**WELWYN HATFIELD BOROUGH COUNCIL
EXECUTIVE DIRECTOR - PLANNING, PUBLIC PROTECTION AND GOVERNANCE**

DELEGATED APPLICATION

Application No: 6/2020/1708/HOUSE
Location: 93 Bramble Road Hatfield AL10 9SB
Proposal: Erection of part single, part two storey side and rear extension, erection of front porch, conversion of existing and proposed roof spaces to facilitate a rear dormer and roof light. Re-tiling of roof and demolition of existing garage and workshop.
Officer: Mr Raymond Lee

Recommendation: Granted

Drawing file: Document / Download

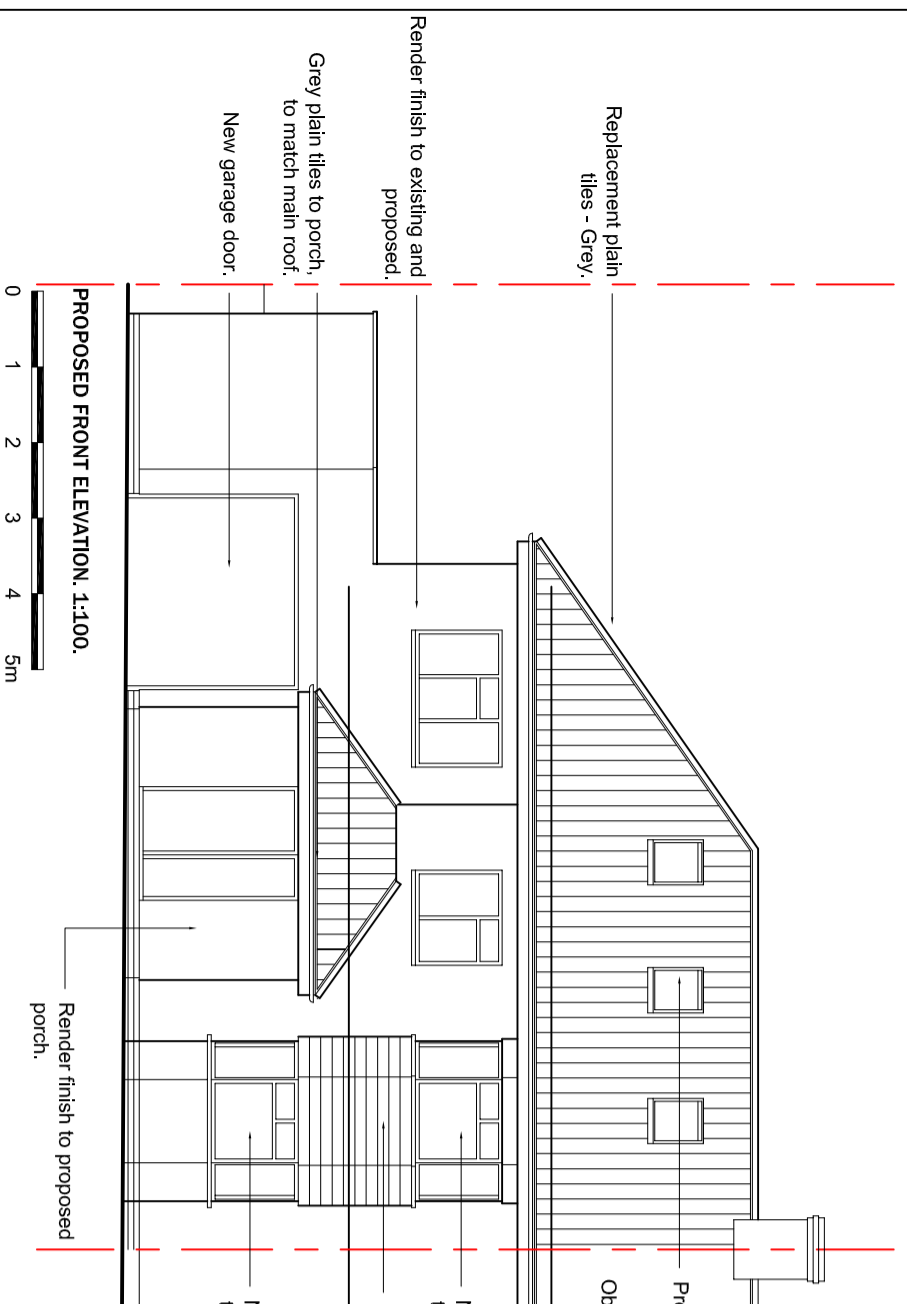
<p>Whilst cumulatively the proposed extensions are substantial in size and scale compared to the original building, it is important to note that numerous dwellings in the immediate locality have been extended in a similar fashion to the proposed development. Examples include numbers: 3, 5, 8, 44, 56, 58, 66, 95, 97, 111 & 113 Bramble Road. As such character of the street has evolved over time where sizeable extensions are commonplace.</p>	
<p>The two storey side extension would step back marginally from the front building line and the follow the existing hipped roof design. This element would also be set in from the common boundary at first floor level and above by 3.5 metres at the front and a minimum of 1 metre at the narrowest point, which is in line with the Council's SDG and in keeping with other side extensions in the area.</p>	
<p>The two storey rear extension would have a hipped roof and is appropriately set down from the main ridge and its depth at 4 metres is just over half the depth of the original house. Furthermore, this part of the scheme would be suitably set in from the party wall with No. 95 Bramble Road at first floor by approximately 2.5 metres to aid in reducing the bulk and massing of the extension at first floor level,</p>

resulting in an addition that would appear subordinate to the rear of the building. The dwelling would retain a large amenity area to the rear as such the resultant dwelling would not appear cramped or contrived within its plot.

The rear box dormer has been set in from the shared boundary by approximately 1 metre as per the adopted guidance and will be lower than the main ridgeline. Whilst the relationship between the rear dormer and roof of the two storey addition is not considered to be of high quality design, it would be largely concealed from the public realm behind the proposed two storey rear and side extension. As such the impact on the street scene is limited. Consideration has also been given to the fact that there are permitted development rights that would allow for development of a similar scale and appearance on the existing building.

The single storey porch extension to the front would appear as a simple and modest addition to the principle elevation with a hipped roof form to match the main property. This part of the proposal would therefore have limited harm to the character of the street scene.

In terms of materials, it is proposed to change the current brown clay roof tiles to grey concrete tiles for both the extensions and main dwelling. Whilst this is a departure from the existing, there is already a significant degree of variation in the colour and style of roof tiles being used in the surrounding area with Nos. 45 and 66 having similar grey concrete tiles. A change from brown to grey tiles would not normally be acceptable for a semi-detached property due to the resulting contrast, however, in this case the resultant dwelling would not appear out of keeping with, or detrimental to, the evolving character of the area. A condition is suggested to ensure the tiles match the existing in terms of their size and do not contrast unacceptably with other tiles in the area. The walls will be finished in render throughout which is in keeping with the original house. The proposed windows will be finished in grey uPVC throughout to replace the existing units which are in white. Again, there are other examples of grey windows in the area so this would be acceptable in this case. Subject to sample of materials being submitted and approved prior to development above ground level, the proposal is considered to be acceptable.

This neighbour is located immediately to the north-west of the application site. As a result of the orientation of the rear extension, the hipped roof proposed and its distance to the common boundary at 2.5 metres, the levels of daylight/sunlight received by this neighbour at their main amenity areas would not be significantly affected. The extension is shown to pass the 45 degree light test on both plan and elevation for their first floor bedroom window. Similarly the proposals would not appear unduly dominant from their main amenity areas as the extension would project no further than their rear building line and the first floor element of the scheme has been hipped and set away from their boundary. In terms of privacy, there are two bedroom windows on the existing building that already have an outlook onto their garden. It is considered that the proposed rearward facing openings would not afford any significant views over and above that of the existing units to warrant a refusal. The proposed Juliet balcony by design does not afford a stepping platform therefore it does not raise any additional concerns relating to privacy than if windows were proposed at the same location.

2. The side facing en suite bathroom window on the south-east elevation of the development hereby approved must be obscure-glazed and non-opening unless the parts of the window which can be opened are more than 1.7 metres above the floor of the room in which the window is installed, and shall be retained in that form thereafter.

Drawing title
PROPOSED SIDE ELEVATION.

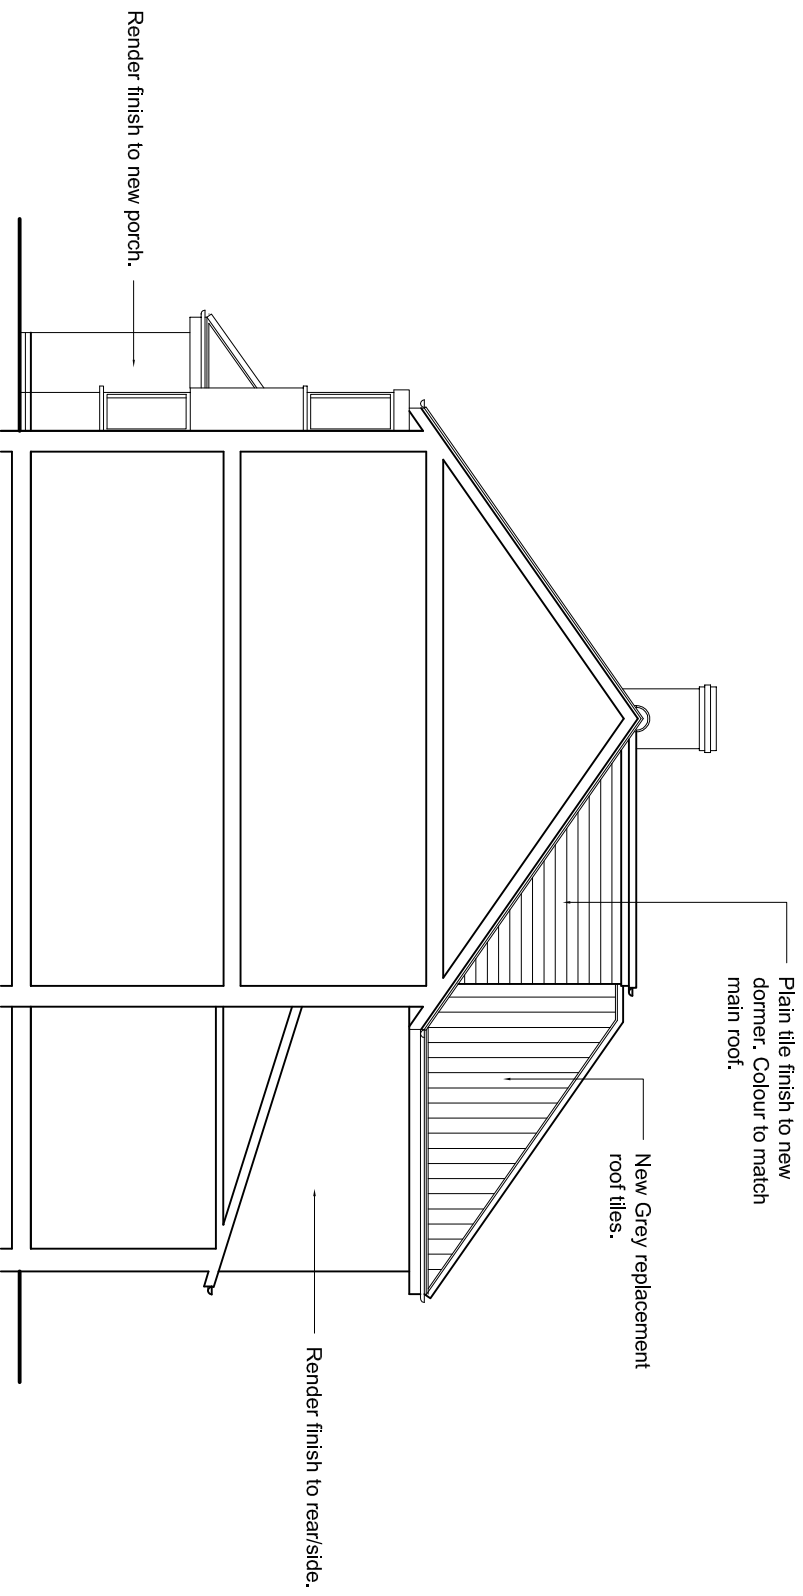
This neighbour adjoins the application site to the south-east. The proposal would not project significantly past their rear building line and there are no side facing windows affected by the additional built form. As a result of the siting, separation distance and orientation, it is not considered that the proposal would result in a detrimental impact on the neighbouring occupiers in regard to loss of light and overbearing impact. In terms of privacy, the side facing window on the first floor is to serve an en suite bathroom which is annotated to be obscure glazed on the plans. This can be secured through planning condition in the event of an approval.
